**Planning Application Ref:** FP/182/21/T

**Location:** 11A Outerwyke Avenue, Felpham, PO22 8JH

**Description of works:** 1no. Turkey oak - reduce limbs by 3m to leave 5m

REF 1

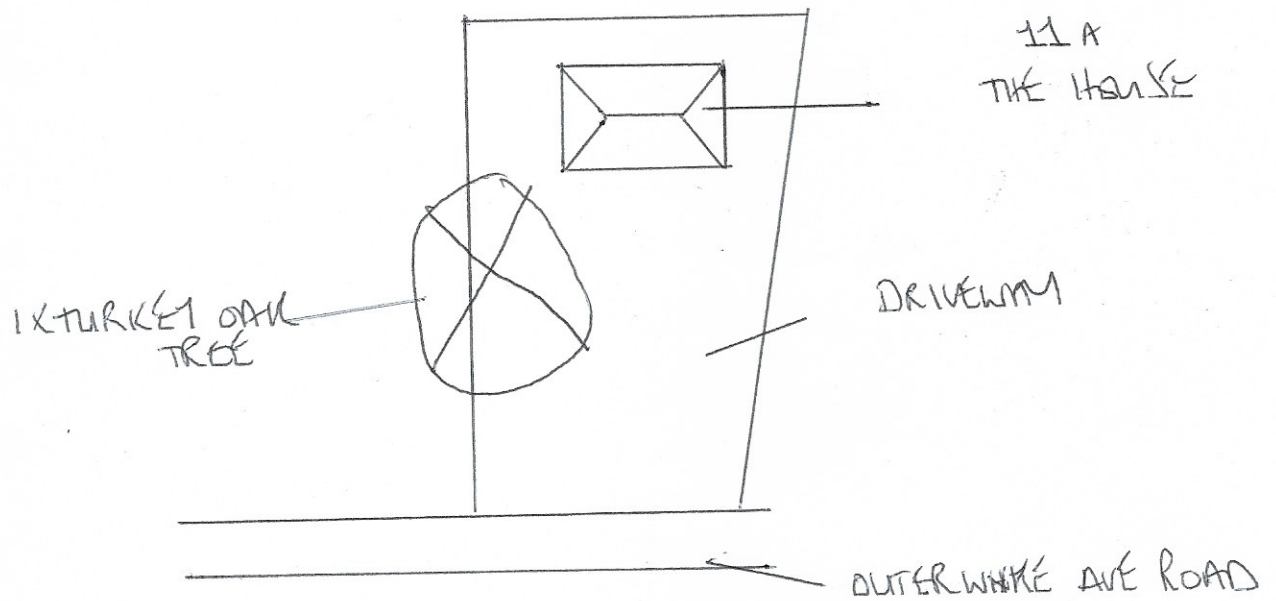
- Outwardly and from a distance (roadside) this tree appears to be in a fine physiological state and assumed to be so in the absence of any evidence provided to the contrary. It presents an attractive crown profile seen from numerous properties and by users of the public highway (footway and carriageway). As such, it has high amenity value.
- A long-established tree that grows at the front of the property and close to the dwelling (11A). It dominates half of the front garden and is probably impacting on the fabric of the building. I assume this is the reason for the application although none were given.
- The extent of crown reduction being sought is approximately -60% of crown volume. In the absence of any overriding and proven safety issue or damage event, such a drastic operation fails to meet the requirements of British Standard 3998:2010 Tree Work - Recommendations.

- This tree requires careful management that respects its age and vulnerability to environmental changes and disease progression.
- The proposal to reduce both height and lateral spread on all aspects by 3m respectively does not comply with 'British Standard (BS3998:2010) Tree work – Recommendations' and would be likely to result in harm to the health and vitality of the tree with large pruning wounds being formed as well as undermining its visual amenity value and impact in the landscape.

- I recommend **REFUSAL** for this application.
